KITTITAS COUNTY COMMUNITY DEVELOPMENT SERVICES

RE: Transmittal of Comments – VA-18-00002 Scholl Variance Transmittal of Comments

RE: VA-18-00002 Scholl

Perry-BACH Additions		
SCALE: _____	APPROVED BY: _____	DRAWN BY OTH BACH
DATE: 4/1/03		REVISED
Site Plan

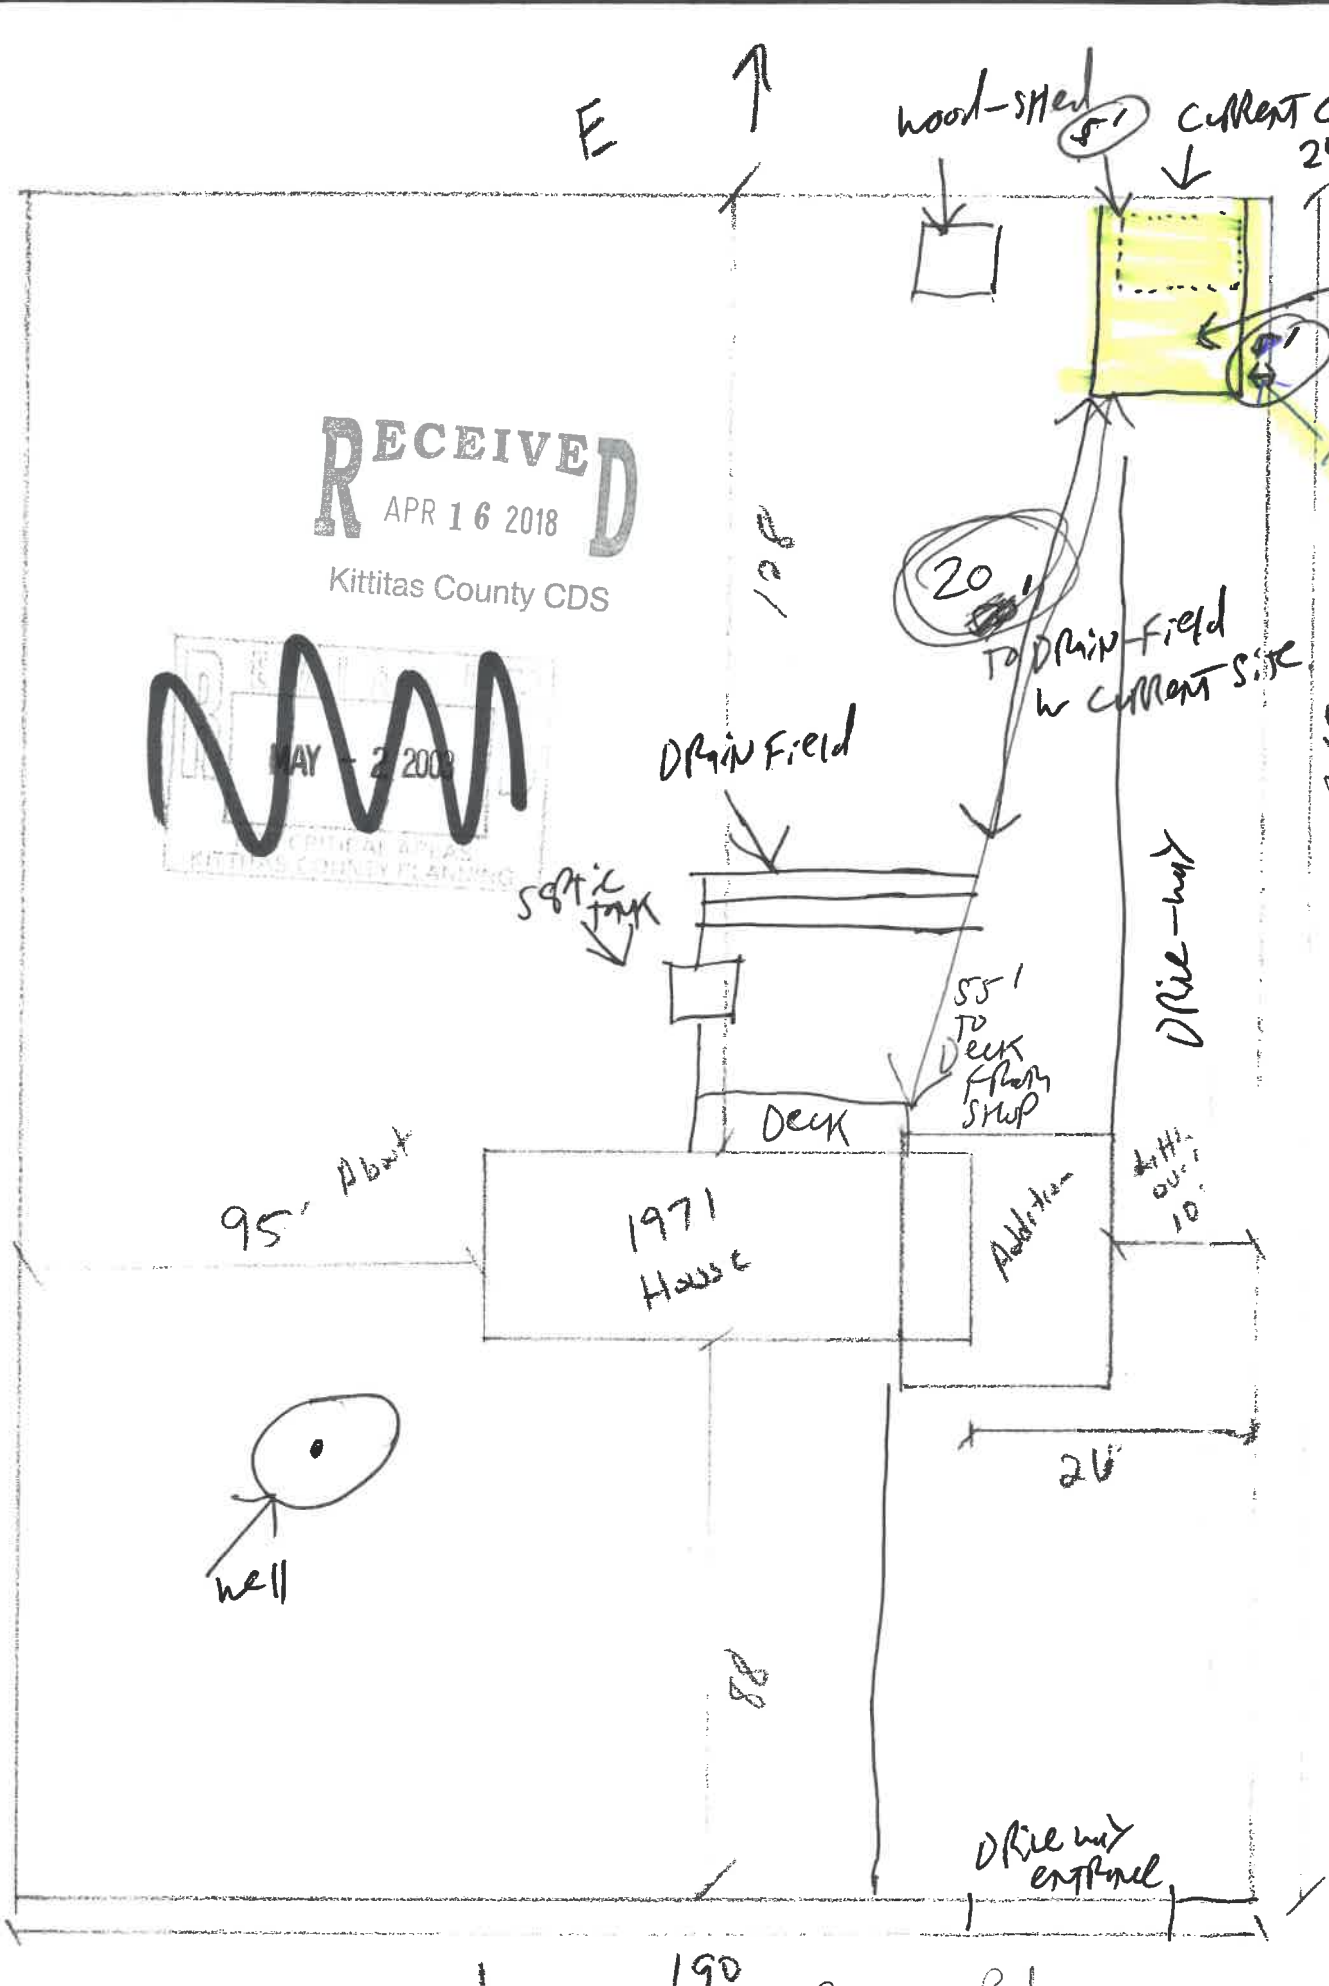
1. The five foot rear setback requested does not need to be fire protected. Any closure encroachment to a property line would require firewall construction. A building eave may encroach into the five foot setback as long as it is fire protected or fire-blocked per the current edition of the IRC or IBC at the time of permit submittal.
2. All construction of buildings and garages shall conform to the International Building Codes and the International Residential Codes adopted at the time of building permit submittal. This includes firewalls and fire separations.

Good morning Dusty,
The Kittitas Reclamation District has no issues with Kittitas County allowing a variance for Mr. Scholl, VA-18-00002 with the condition that the shop is not

constructed on the KRD Right of Way and the construction of said shop does not interfere with KRD operations. Please let me know if you need anything further.
Keli Bender
